Ecological comments

Planning Application No: 3/2013/0981

Proposals: Outline application for residential development comprising 20 dwellings (including 6 units of social housing), 3 close care apartments and a 60 bed care home (all matters reserved for subsequent approval)

Location: Land at Chatburn Road, Clitheroe

Plan 2: Bat Risk Assessment of Trees Plan

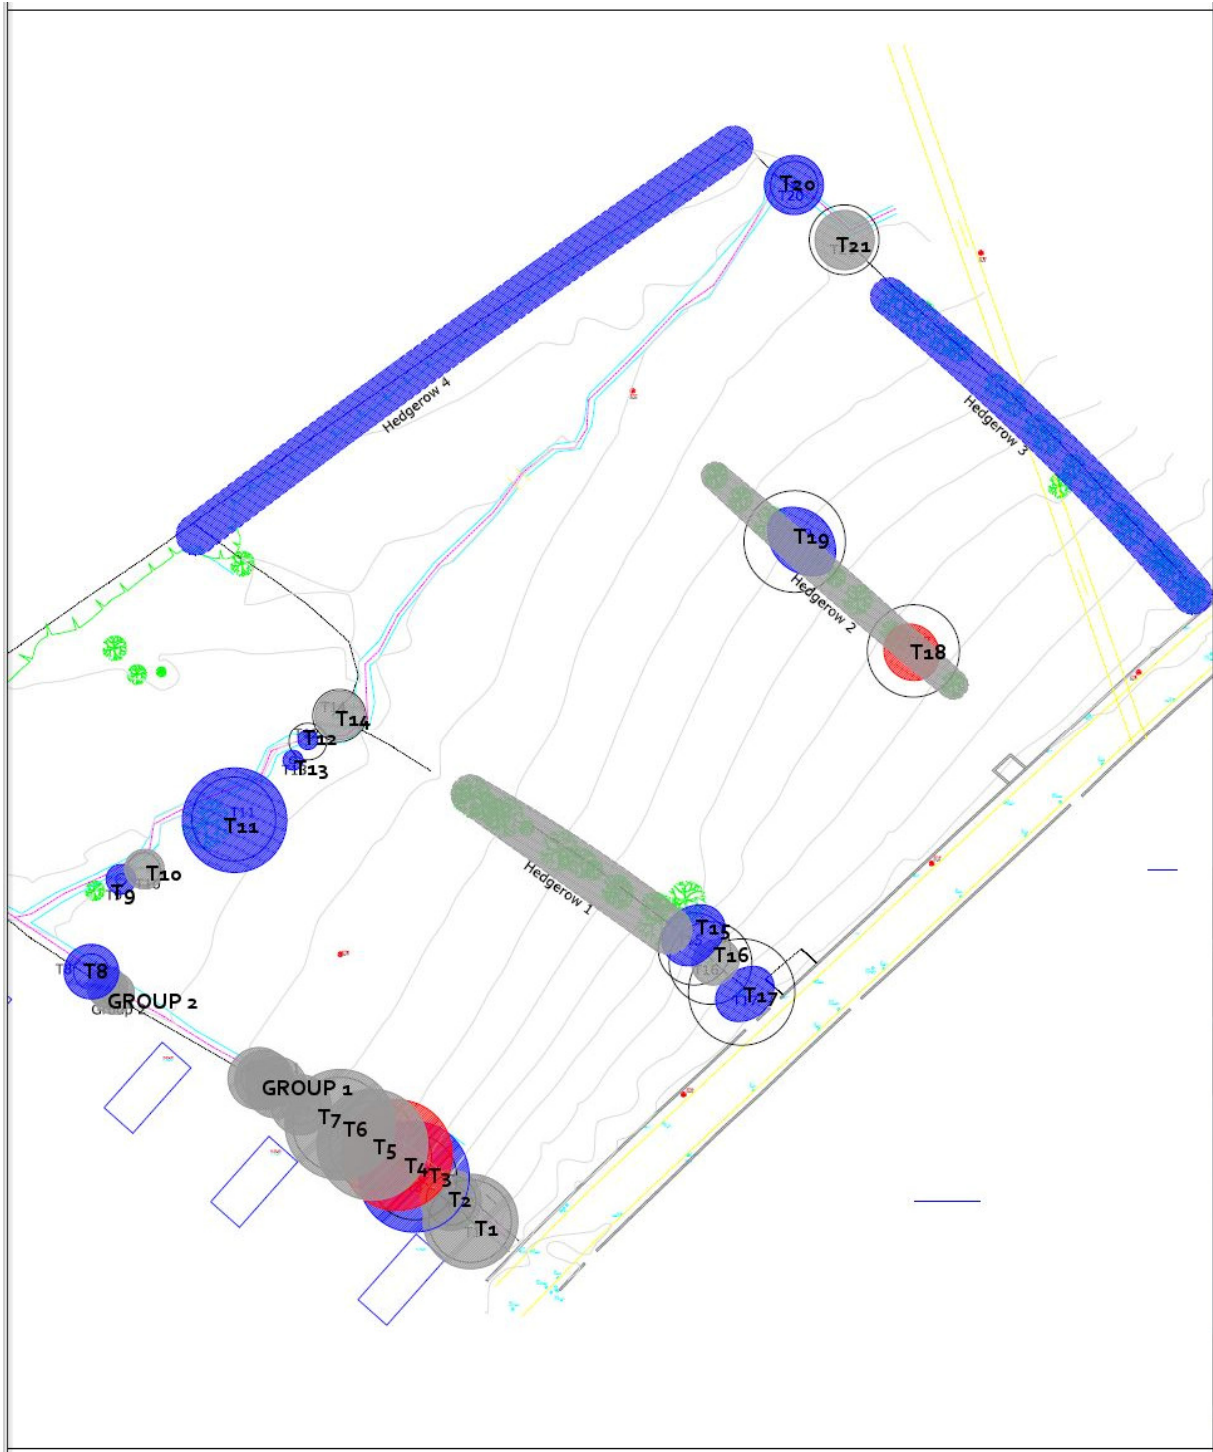
From the illustrative plan it appears that the majority of trees are to be retained which is appropriate. However the tree report recommends the removal of dead wood of a number of trees (T15, 16, 17, 19) and from the illustrative plan and the design and access statement, it appears that hedgerow 2 and T18 are to be removed to facilitate development.

The tree report recommends that dead wood should be removed from T16, T17 and T19 and from the illustrative plan it appears that T18 will be removed as part of the proposal. With the exception of T19 (where no details have been provided on its potential to support roosting bats), these trees have been identified as trees with moderate/low potential to support roosting bats (2b category). No detailed descriptions of the roosting opportunities provided by each tree has been provided (apart from some crevices). However, the tree report acknowledges that T18 has considerable dead and damaged wood within the canopy, that there are large cracks within the main stem and cavities and a major wound on eastern side. Such features may have the potential to support roosting bats.

T19 – Ash tree

Whilst T19 is to be retained, from the proposed illustrative plan, it appears that it would become isolated within the design of the development. No information has been provided within the ecology report on the potential for this tree to support roosting bats. The proposed development could potentially isolate a tree with the potential to support roosting bats. This may reduce its suitability for roosting bats. It should be ensured that the development is designed to maintain and enhance habitat connectivity between this tree and suitable bat foraging habitat. For example, incorporation of a native hedgerow to link the tree to the stream or existing boundary hedgerow would be beneficial.

DRAWING TITLE
Site Plan - Indicative Layout

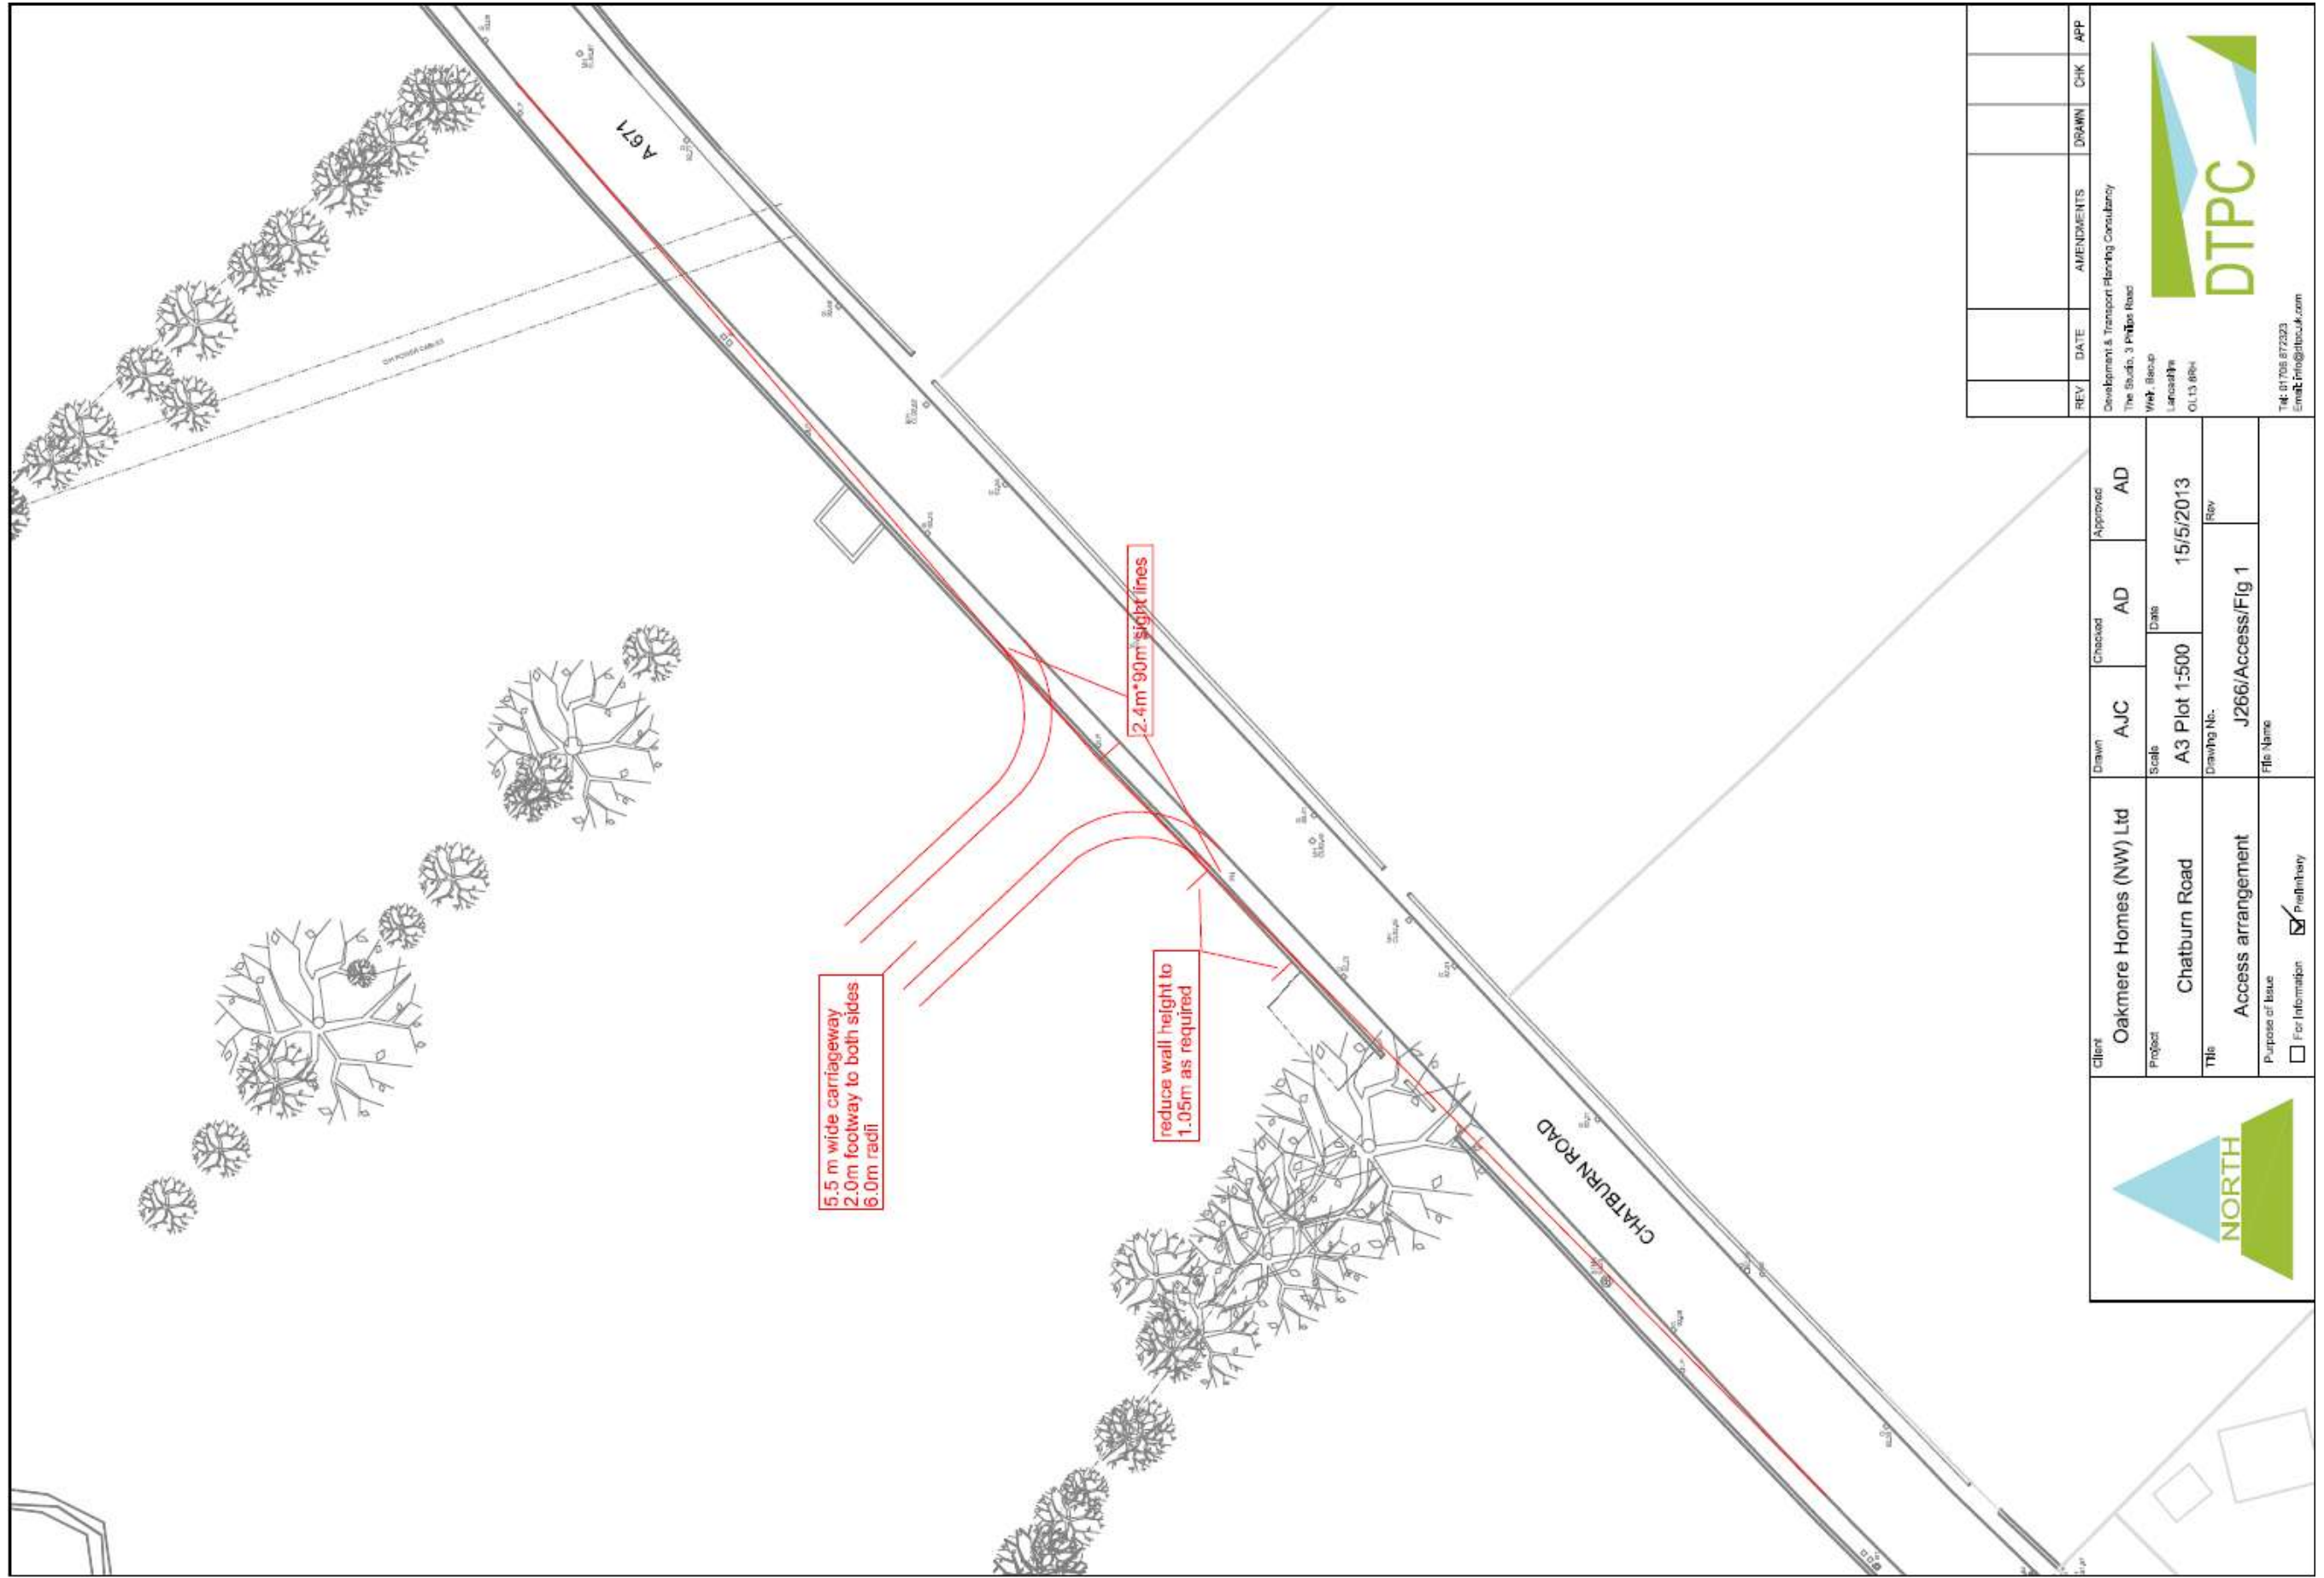
From the illustrative plan, it appears that the central defunct hedgerow is to be removed. Any unavoidable losses of habitats should be adequately compensated for through appropriate landscaping and installation of bird nest boxes as appropriate. It appears that there is space within the application area to adequately compensate for any losses in relation to the potential loss of hedgerow/trees, through additional planting/management of the retained hedgerows/through a sensitive landscape plan. I recommend that native species and species of known value to biodiversity are used.

The illustrative plan indicates that whilst no housing is proposed on the marshy grassland, it appears that it will form amenity land and pedestrian access into this area is proposed. This does not appear to have been addressed in the ecology report. In the absence of further information, it is not known whether the grassland supports such species. However Lancashire County Council does have access to records for Lapwing and Snipe in the wider area. If the site supports ground nesting birds, the proposed development would have potential impacts on such species either through loss of habitat and/or potential disturbance/increased recreational pressure. From the illustrative masterplan, it is not clear that the proposed development could accommodate for such
